Essex Local Access Forum (ELAF) deadline 5 submission (10 May 2023)

Interested Party ref 2033138

Drawing title: **STREETS, RIGHTS OF WAY AND ACCESS PLANS**  
SHEET 18 OF 21

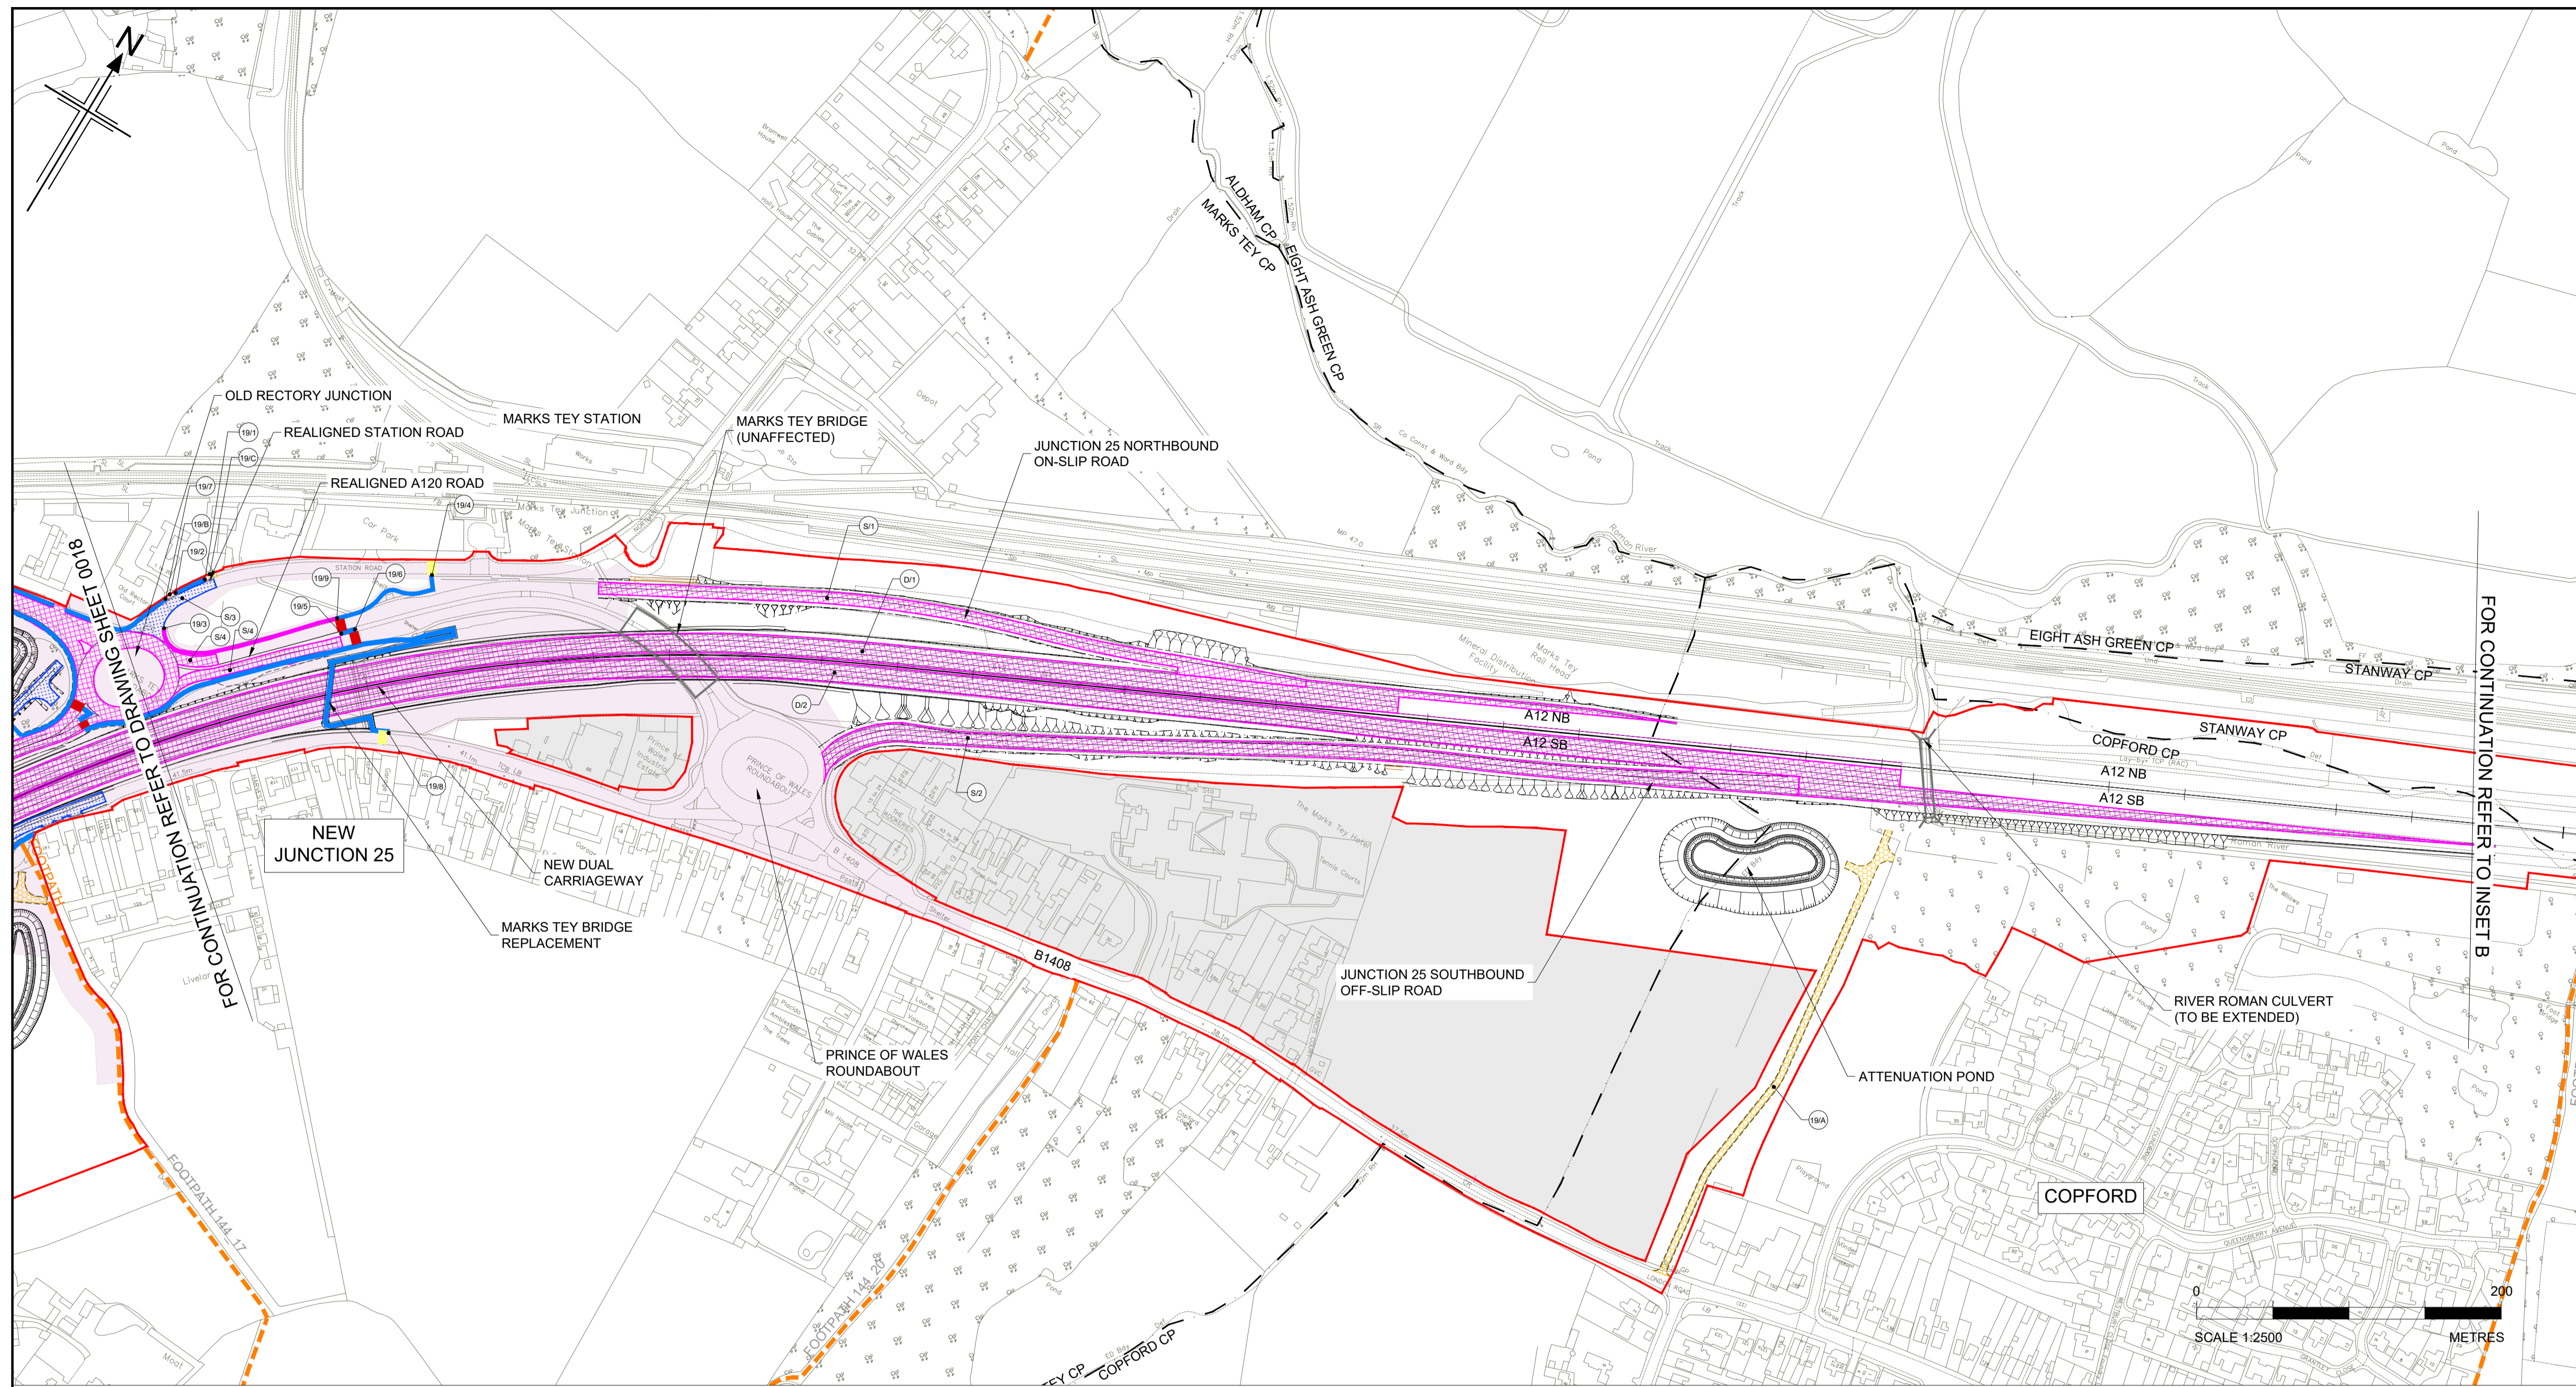
National Highways propose replacing two existing bridges over the A12 at the north end of Feering with one bridge (ref: sheet 15 of Streets, Rights of Way & Access Plans Part 2 REP4-004). This is a diminution of the WCH network and is not in keeping with NPPF paragraph 100, ECC's ROWIP and also not in keeping with National Highway's own objectives of... *"improving accessibility for walkers, cyclists, horse riders, and public transport users."*

The Feering FP 15 and Prested Hall Drive will be severed; Threshelfords FP 18 / farm accommodation bridge will be demolished and will be replaced by Prested Hall Bridge, a road bridge with a cycleway along one side; Feering FP 18 will become a foot-cycle-way in part and will follow a longer convoluted route.

Removal of two bridges and replacement by one, means that local people will no longer be able to undertake a short circular walk over Threshelfords Bridge, along FP 18 and then returning along the drive of FP 15. As there will be 1000 new homes in this area of Feering, the loss of a circular leisure route is deplored. The East Anglian Farm Ride that connects at the north end of Prested Hall Drive will also be negatively affected.

ELAF repeat their request for a WCH bridge over the new A12 to enable continued direct access to Prested Hall & its leisure facilities and the by local residents.
